Transport

EXHIBITION OF ENVIRONMENTAL ASSESSMENT FOR 132-138 KILLEATON STREET, ST IVES (MP10_0057)

I refer to your letter dated 24 August 2010 seeking advice on the Environmental Assessment for the above mentioned project. Transport NSW (TNSW) appreciates the opportunity to provide input to this application.

NOTES:

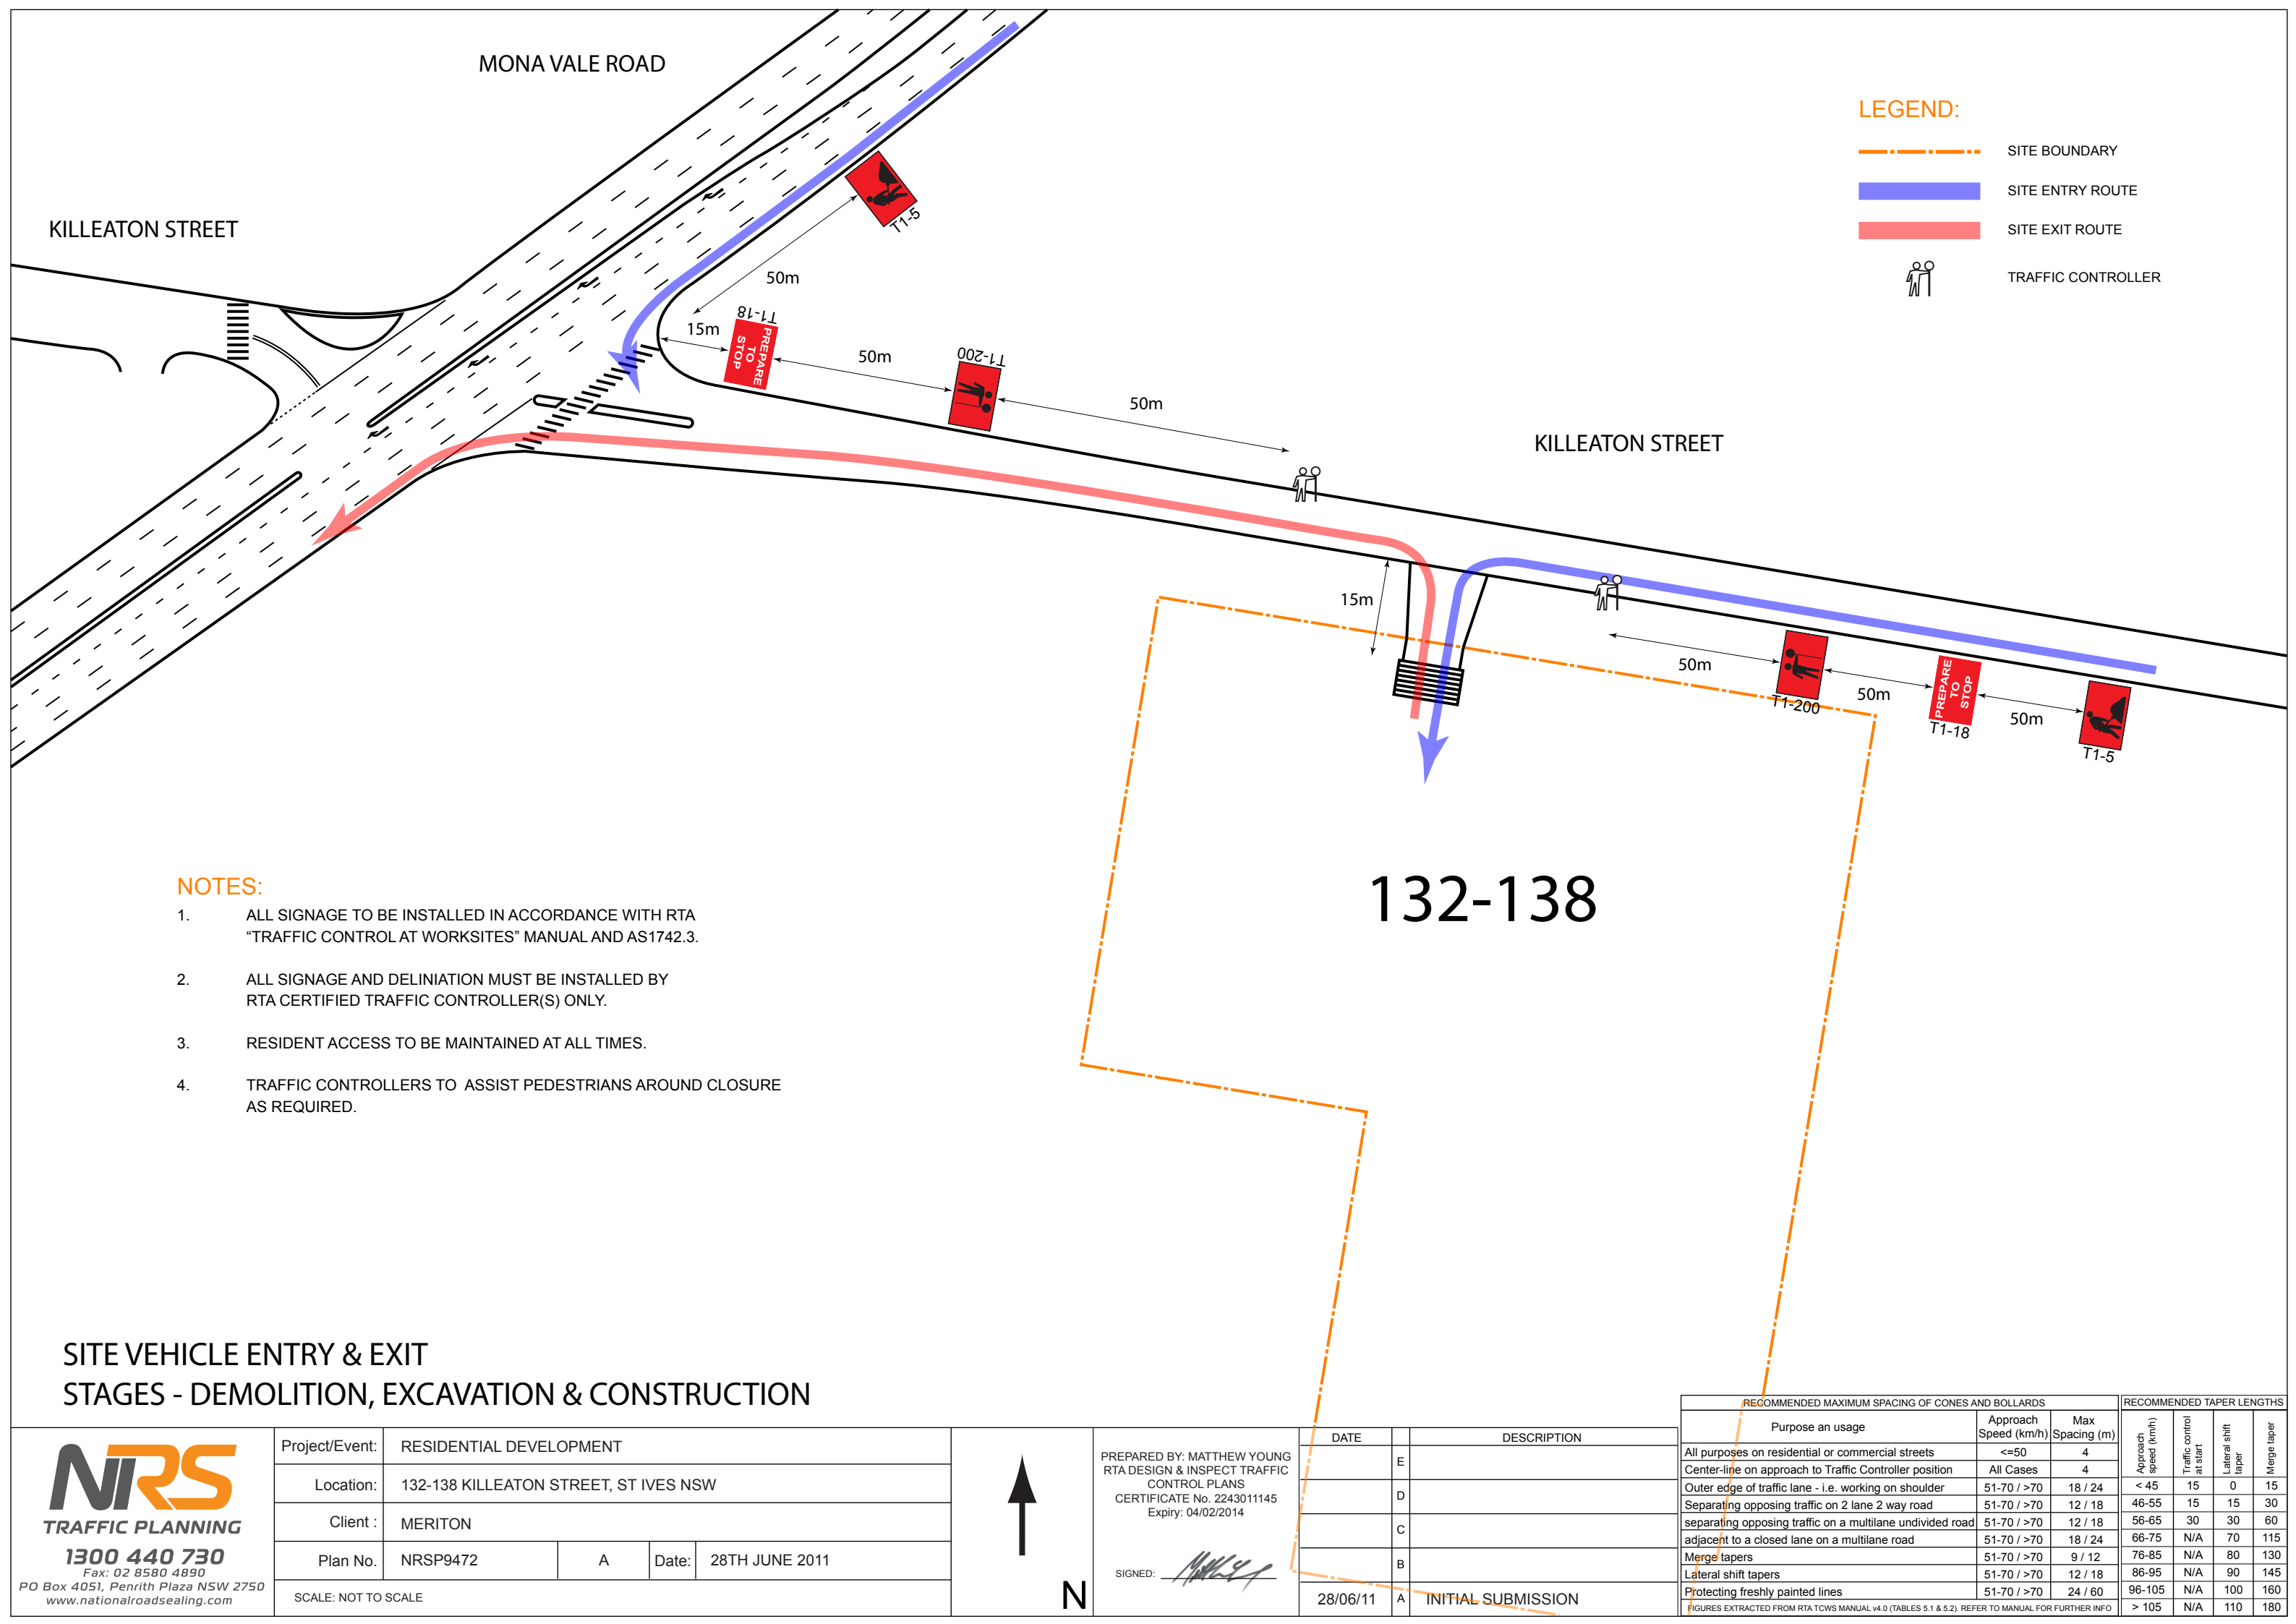
3. Preparation of a Construction Traffic Management Plan (CTMP) to mitigate any potential impacts to accessibility, amenity and safety of public transport users and people traveling on foot or bicycle during construction.
